**Application Number SSI 7485****WestConnex M4-M5 Link – Modification 2 The Crescent overpass**

**Martin O'Dea**  
**Lilyfield**

Figure 4-3 The Crescent, Johnston Street, Chapman Road intersection options

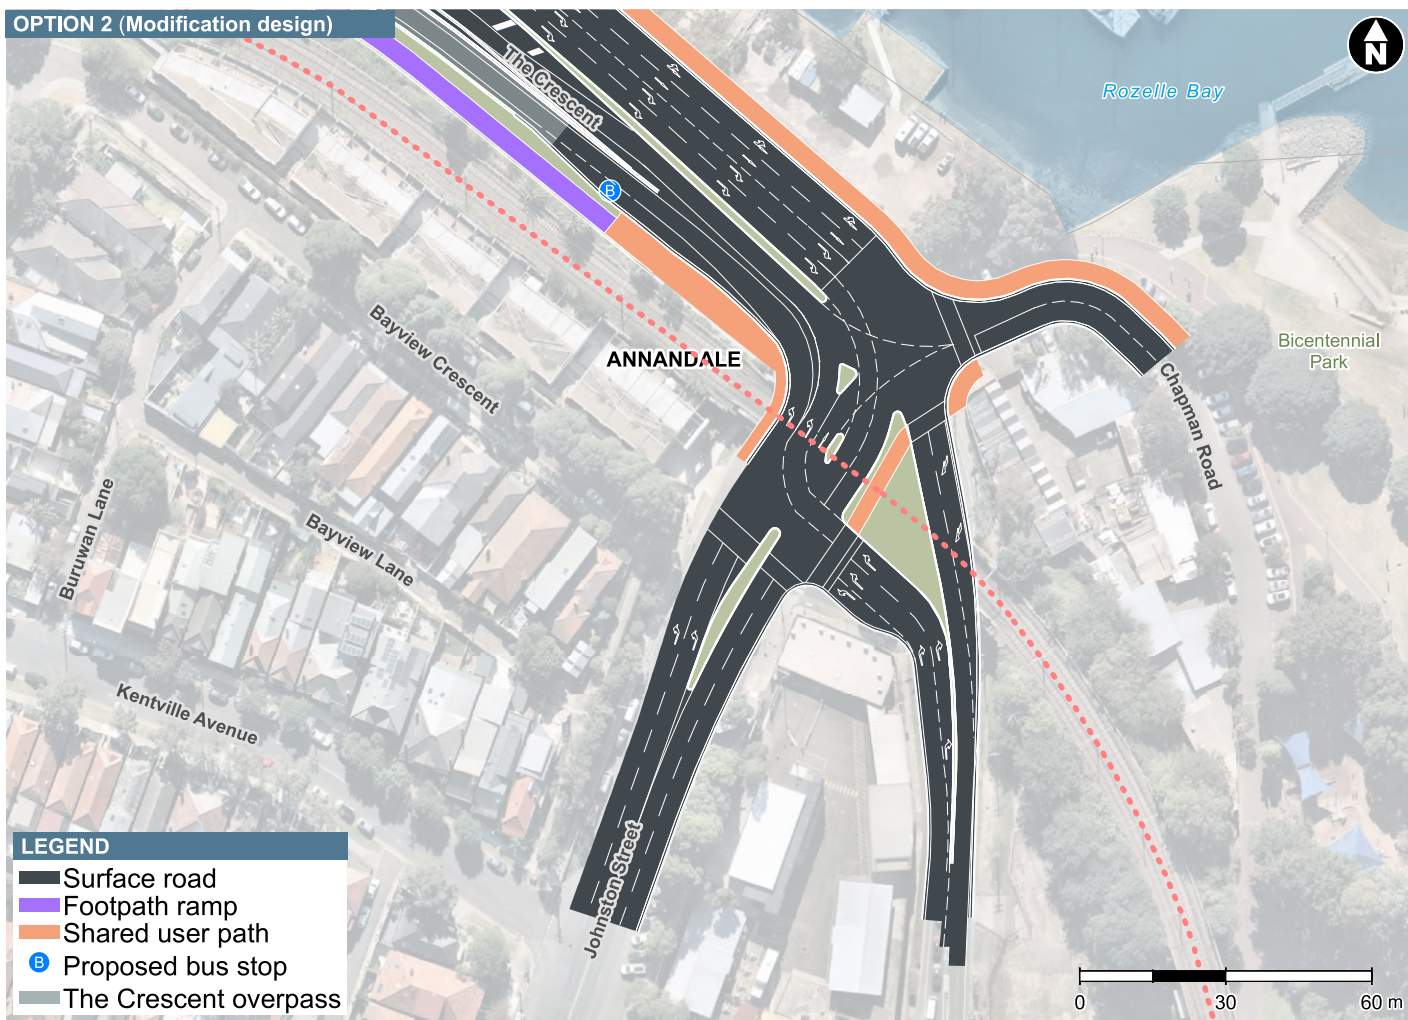
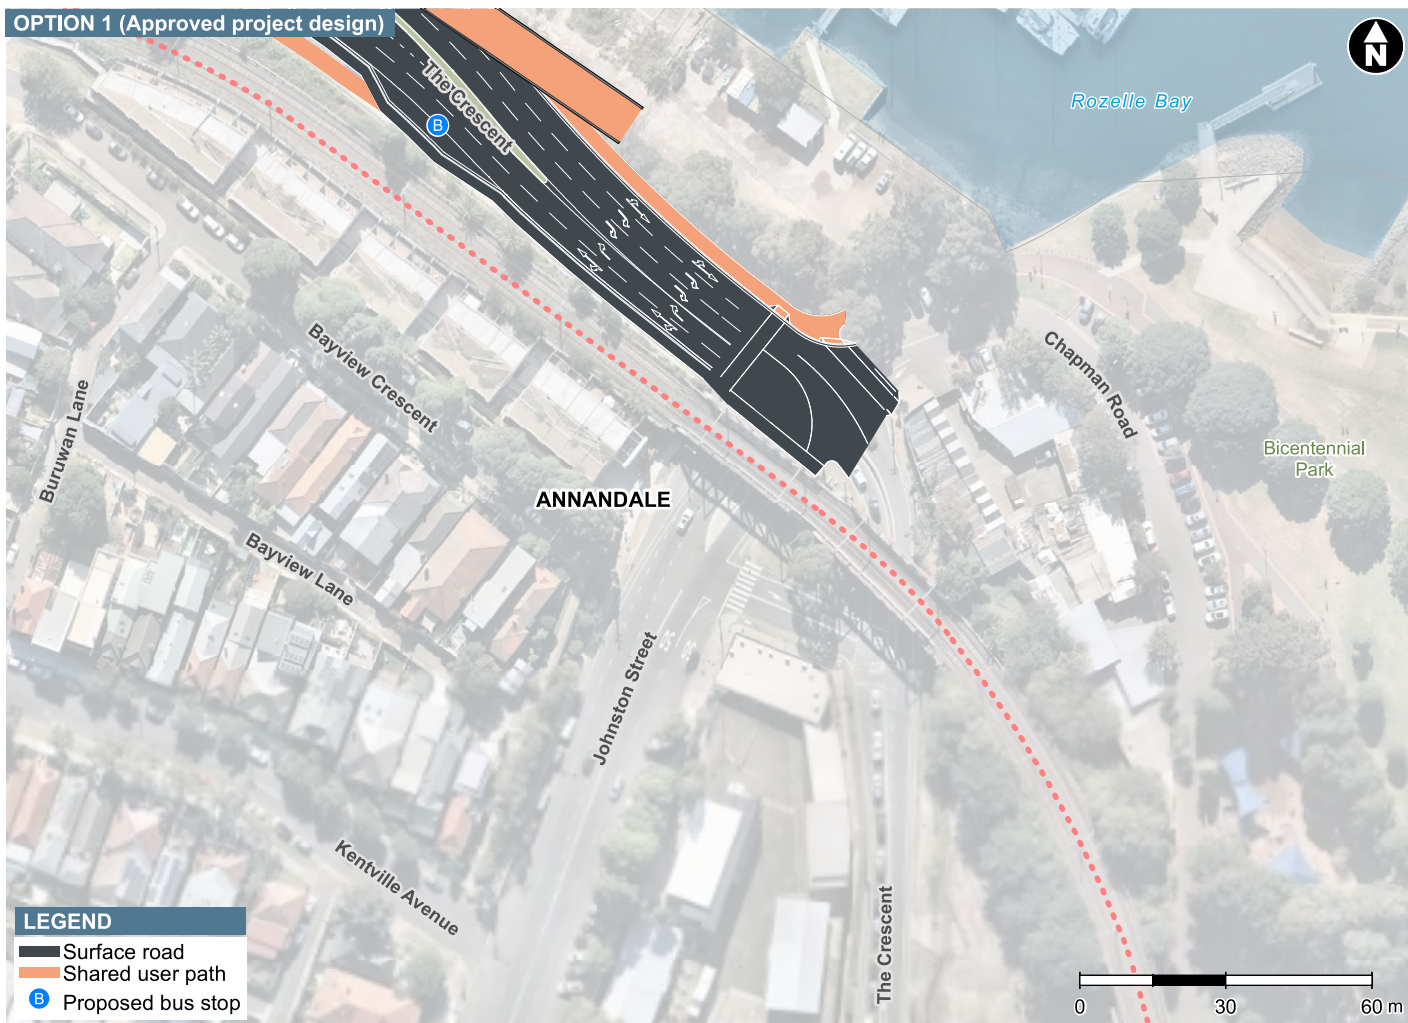
The modification report table 4.1 reviewed three options. 1; Traffic lights, 2; Underpass and 3 overpass. The decision to proceed with Modification 2 has not adequately reviewed the two alternate options that had far better urban design outcomes.

*Option 2 tunnel not adequately reviewed.*

The Tunnel option however was discarded due to constructability and other concerns. The design reviewed, however was a 165m tunnel. By exceeding 120m it then required mechanical ventilation and escape routes. This drove the tunnel lower for the ventilation equipment, and therefore made it longer, and meant that it exited past James Craig Road and the Crescent to the south. All this dramatically pushed up cost, complexity, and workability.

We believe however that the underpass option should have come from the premise of making it shorter than 120m so that it sat below the threshold for ventilation. This would mean that it could be shallower, therefore shorter and substantially cheaper. To do this it needs to come from the centre lane, necessitating the relocation of the bus stop to just south of Johnston Street.

The intention should be to maximise the open slot trench to ensure the underpass section itself is no longer than 120m, so that it does not need to be mechanically ventilated. This would mean that it could be shallower, therefore shorter and with reduced cost and complexity. This might include the ramp from the centre lane, which may require the relocation of the bus stop location. The gradients of the down ramps be considered so that the ramp allows the existing pedestrian crossing at Johnston Street to remain.

1.1 Review Option 1 in terms of traffic light phasing. This option provides maximum traffic movement options.

- Keep the tunnel shorter than 120m to avoid need for mechanical ventilation and emergency egress to reduce cost and complexity. The remaining areas to be open slots. This is a far better urban outcome.
- Consider relocating bus stop south of Johnston Street to have underpass in middle lane to reduce tunnel length.
- Ensure northbound tunnel entry starts after Johnston Street.

- Solve waterproofing issues with precast box solution with waterstop joints or other appropriate means as has been applied to other Sydney tunnels (LCT and SHT).
- Concerns about constructability should be reviewed to investigate temporary traffic diversions through the goods yard

Figure 4-4 Elevation: Indicative view of The Crescent overpass

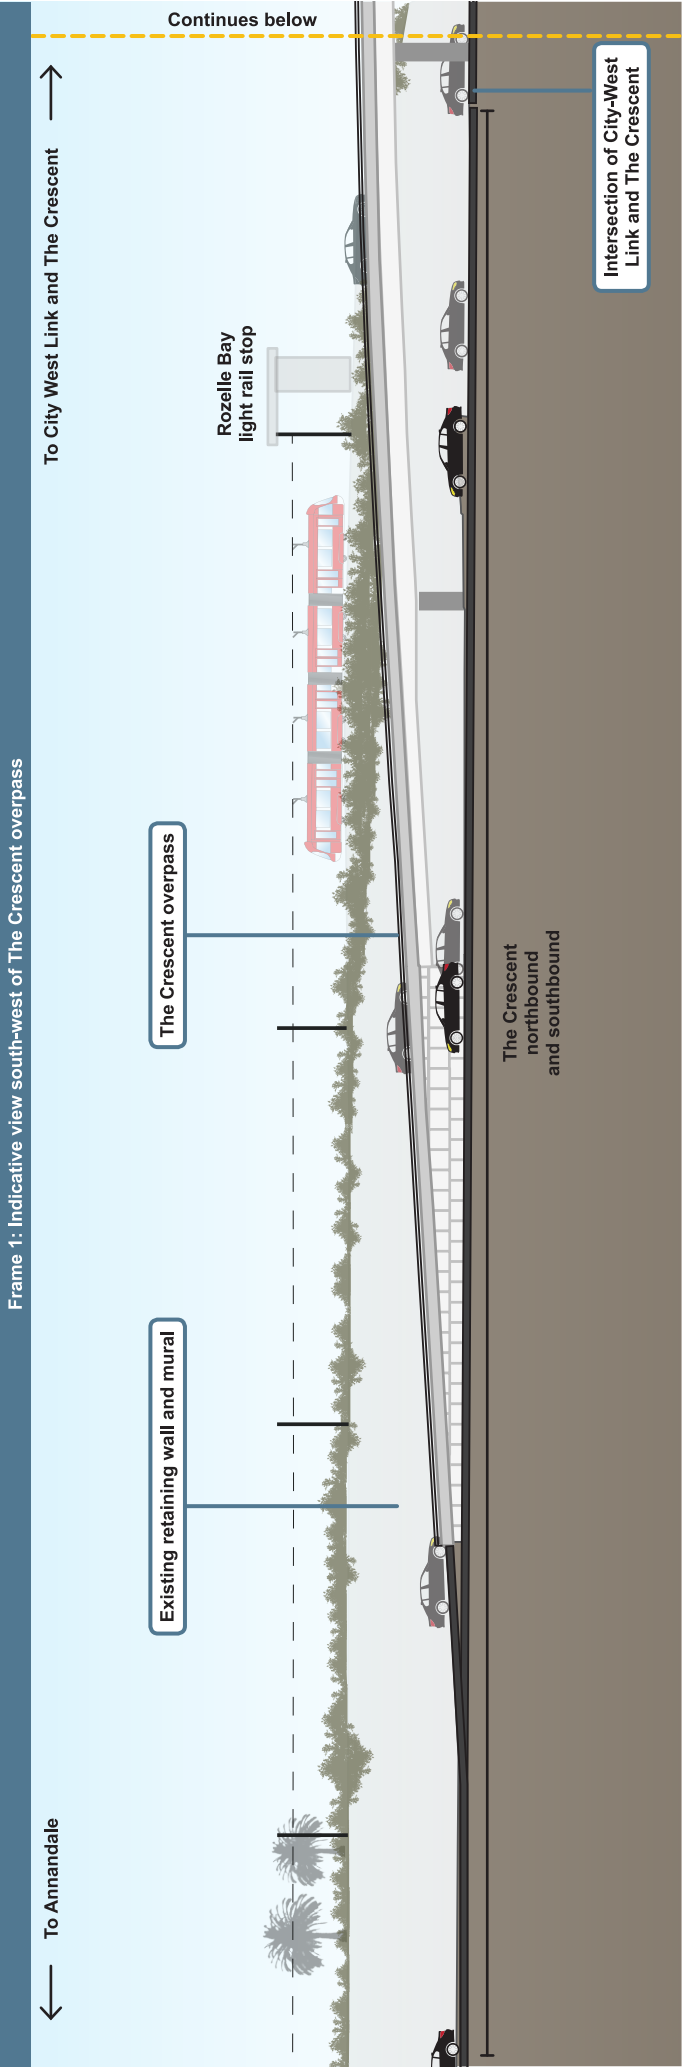
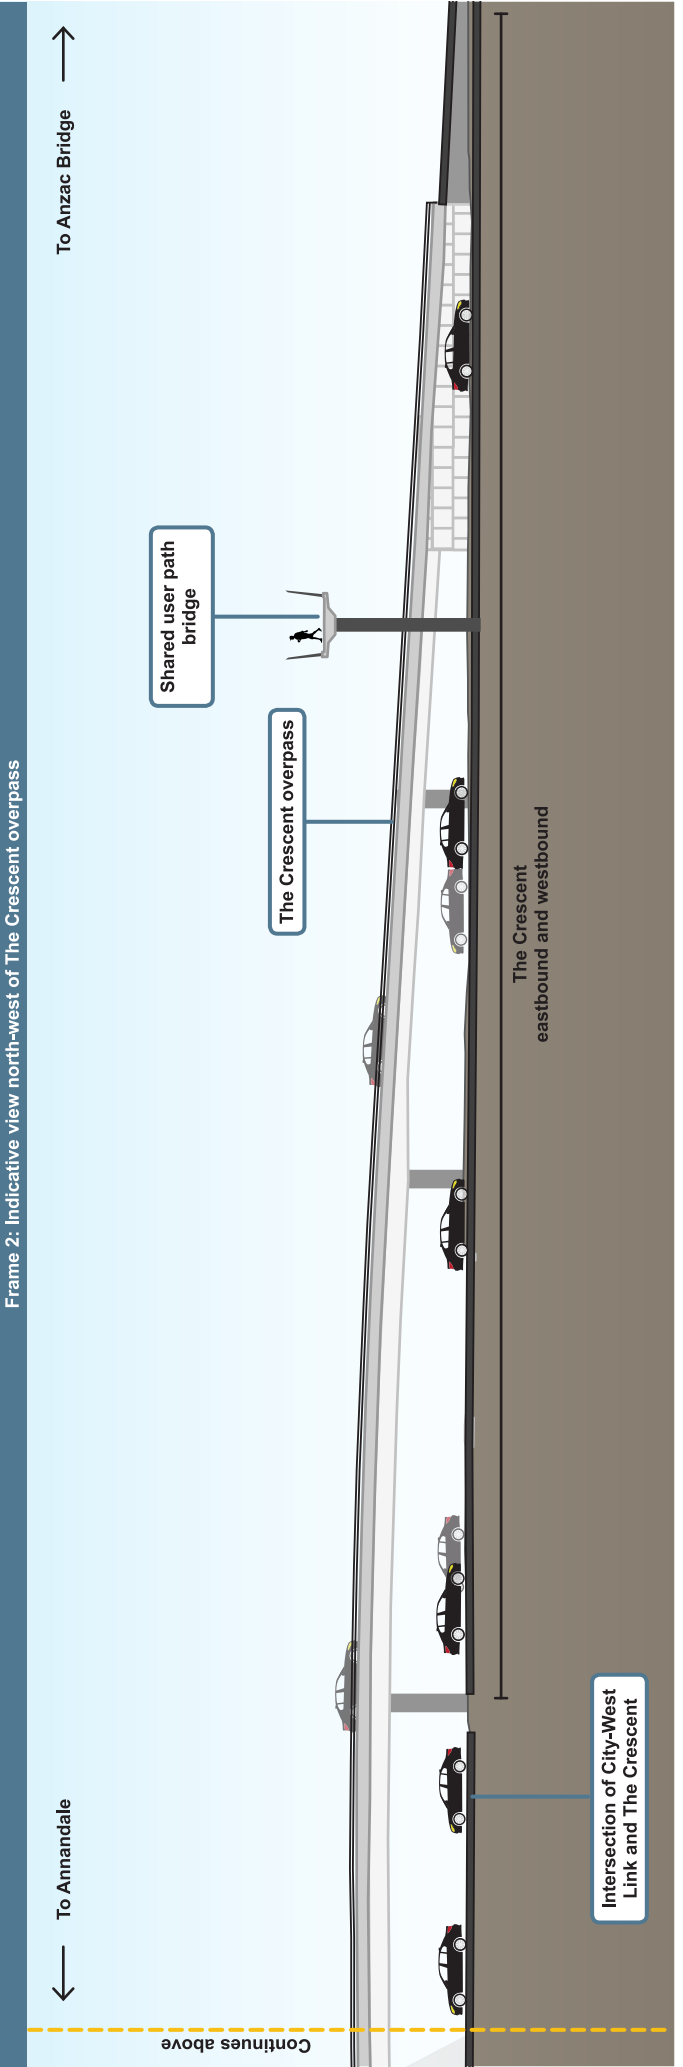
The above ground road overpass is what has primarily changed from the original EIS design, with multiple flow on effects. The decision to put in an overpass has driven a range of undesirable flow on changes particular around pedestrian connectivity, including the need to move the green bridge west. It has led to the relocation of the green link, the addition of a new pedestrian bridge, and associated visual impacts and reductions in pedestrian connectivity. The overpass blocks views from the relocated green bridge to the harbour.

*Overpass blocks views from green bridge*

The Overpass has a design speed of 60Km/Hr which makes it even higher than it needs to be and as a result blocks harbour views from the relocated green bridge. The current illustrations do not show street lighting which will extend up even higher.

1.3.2 The option 3 overpass needs to be lower than the green bridge so that you can see the water from the green link.

Figure 4-5 The Crescent/Johnston Street/Chapman Road intersection

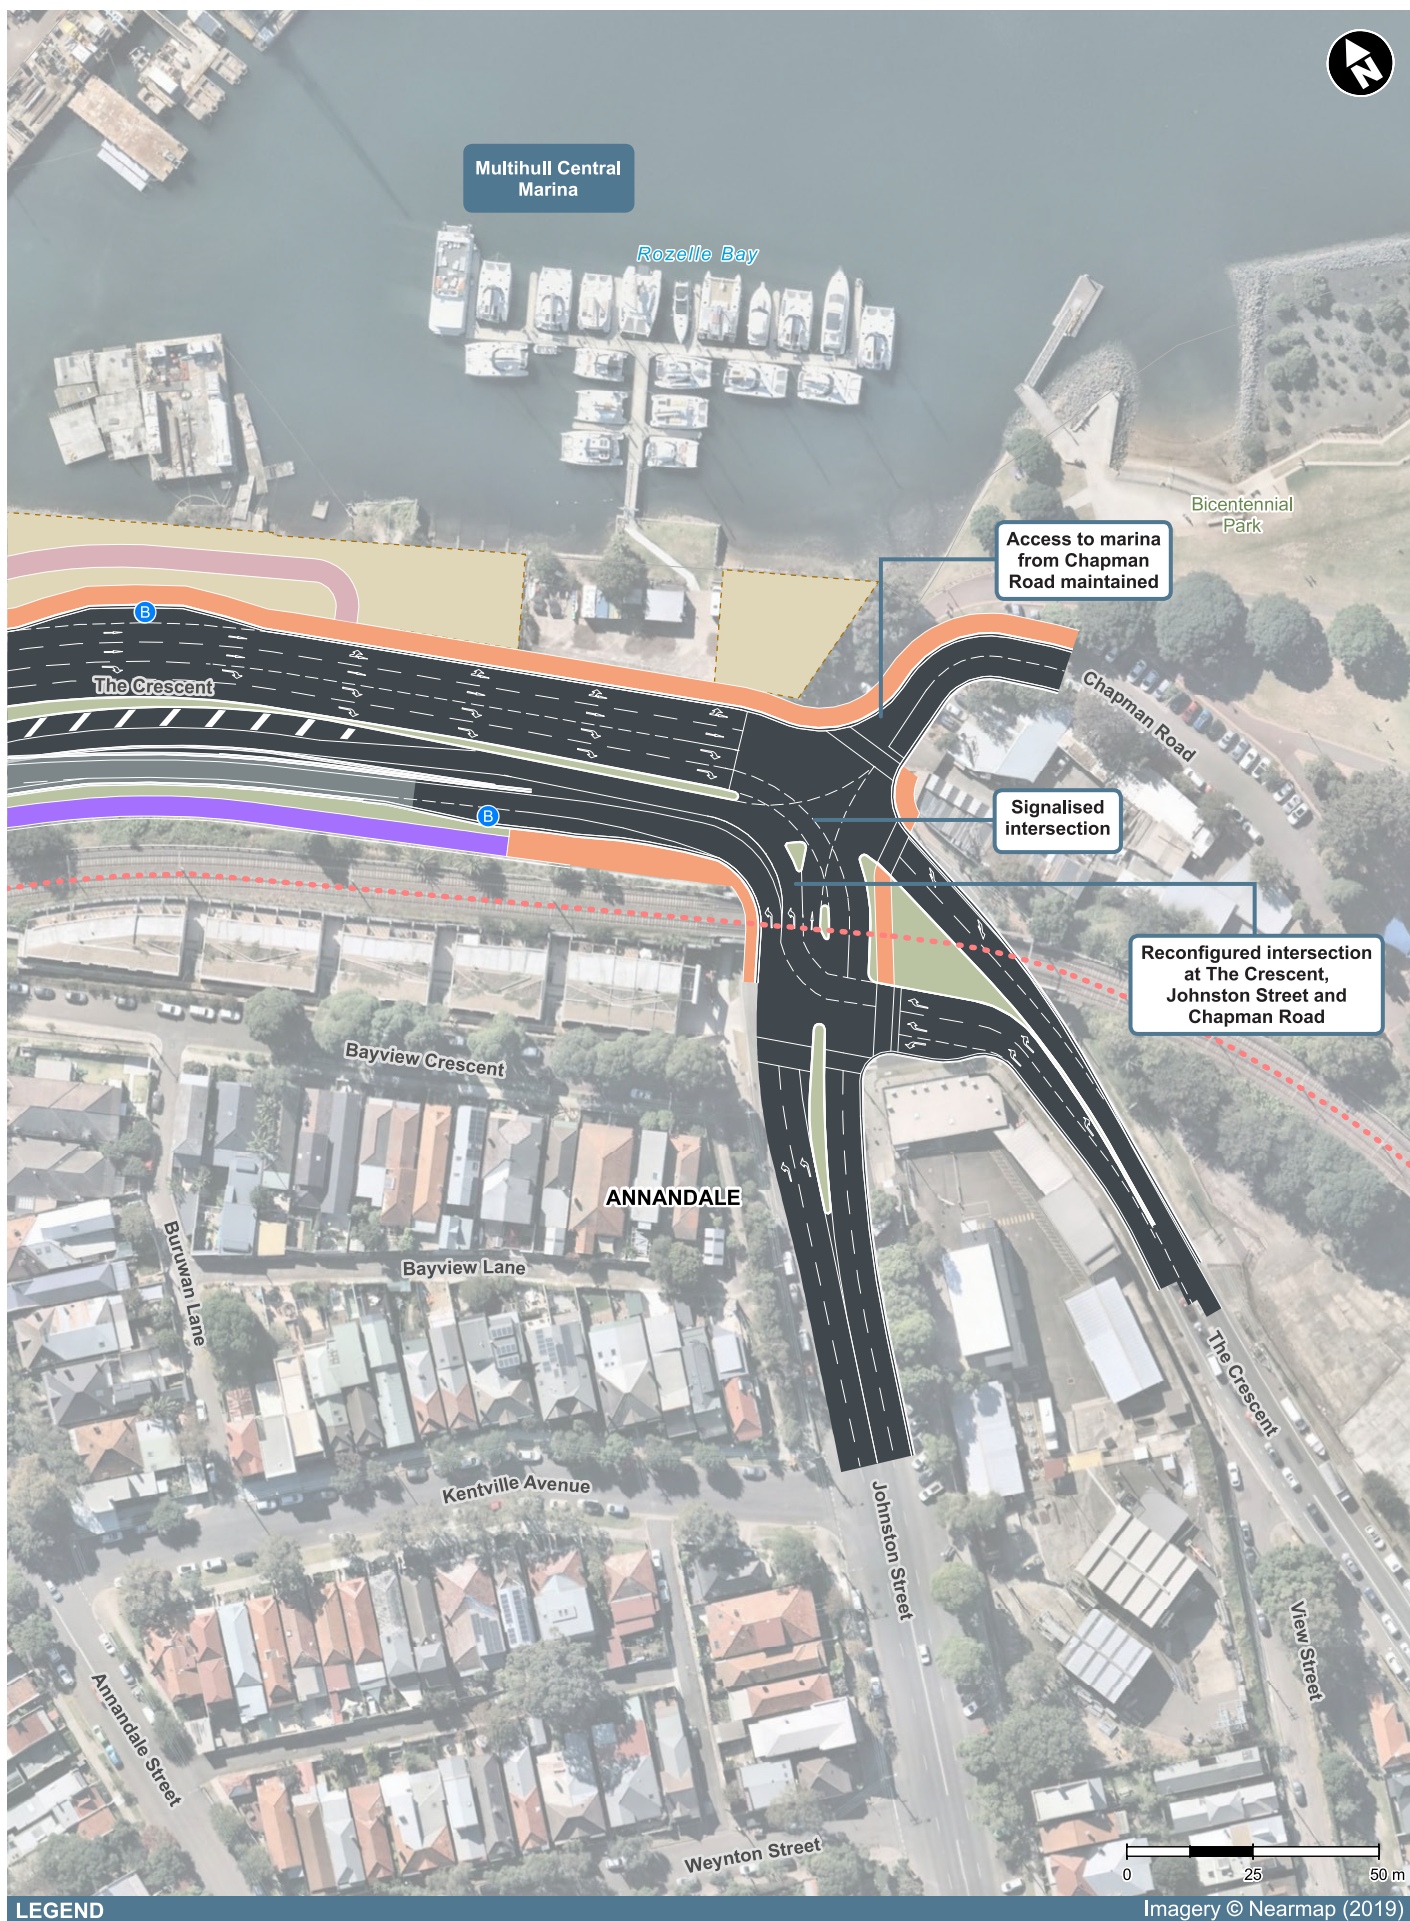
- Removal of direct park to park connectivity between Rozelle Goods yards and Glebe Foreshore by relocating the green link, (See notes below)
- Tortuous 4 traffic light pedestrian crossing at Johnston street The crescent
- No at grade wheelchair / pram / kids on bikes connectivity through Buruwan Park and the western side of the crescent. ( see notes below)
- Addition of a third crossing into Rozelle parklands, but one that has ended up 120m longer than necessary to be able to get over the overpass, and its flow on visual impact issues.

This modification would remove the option to turn right out of Johnston Street into the Crescent to destinations such as the tramsheds, Glebe, Sydney University etc. This will increase traffic through local streets including Piper Street and Booth Street as they seek alternate routes.

Intersection redesign should investigate the ability to easily turn right to access Glebe, The Tramsheds and other destinations.

2.2 Simplification of the Johnston Street crossing of the Crescent. Change to a single traffic light crossing in the current location on the Northern side of Johnston Street as currently exists.

4.1 Consider options to retain the right turn lane from Johnston Street to The Crescent in the redesign of the pedestrian intersection and location of the traffic lights.

Figure 4-6 Elevation: Indicative view of Rozelle Rail Yards Pedestrian and Cycling Green Link

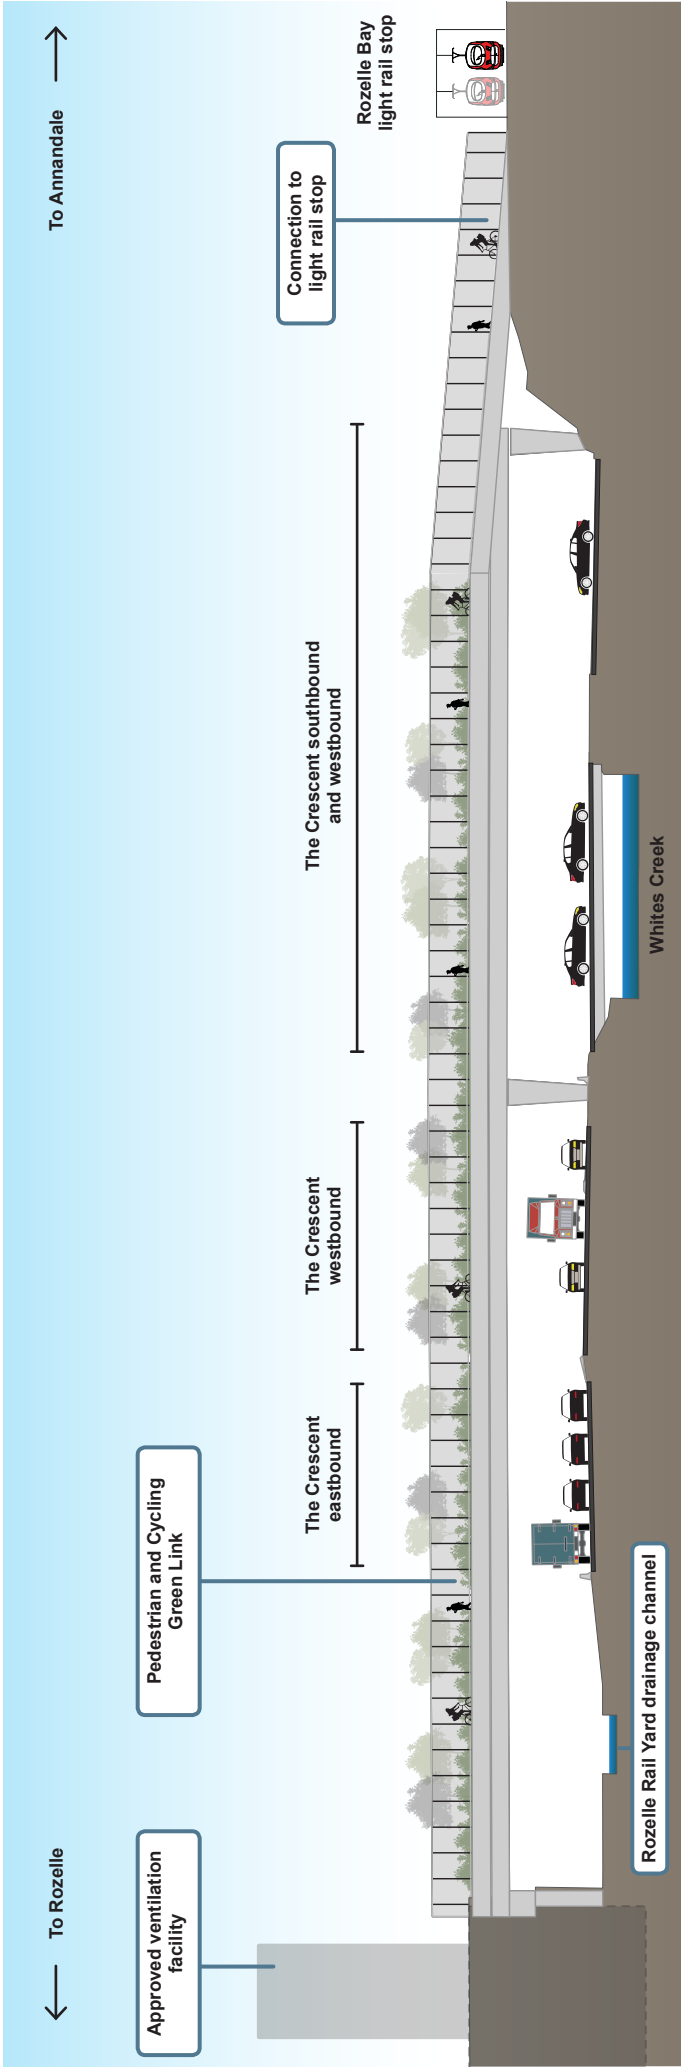
The green link was originally intended to provide a seamless grade separated connection for pedestrian between the Glebe foreshore parkland and the new Rozelle Parklands. The relocation of the green link to the west due to the overpass now necessitates the crossing of the Crescent.

Relocating that green link to the west of the intersection of The Crescent and City West Link puts the needs of motorists ahead of pedestrians and cyclists. By having it on the western

side, you now need to cross the four lights at the Crescent rather than no road crossings at all. The original intent was safer and allowed for greater connections in and around the parklands.

2.1 Provide for the direct grade separated connection between the Glebe Foreshore and the new Rozelle Parklands via the green bridge.
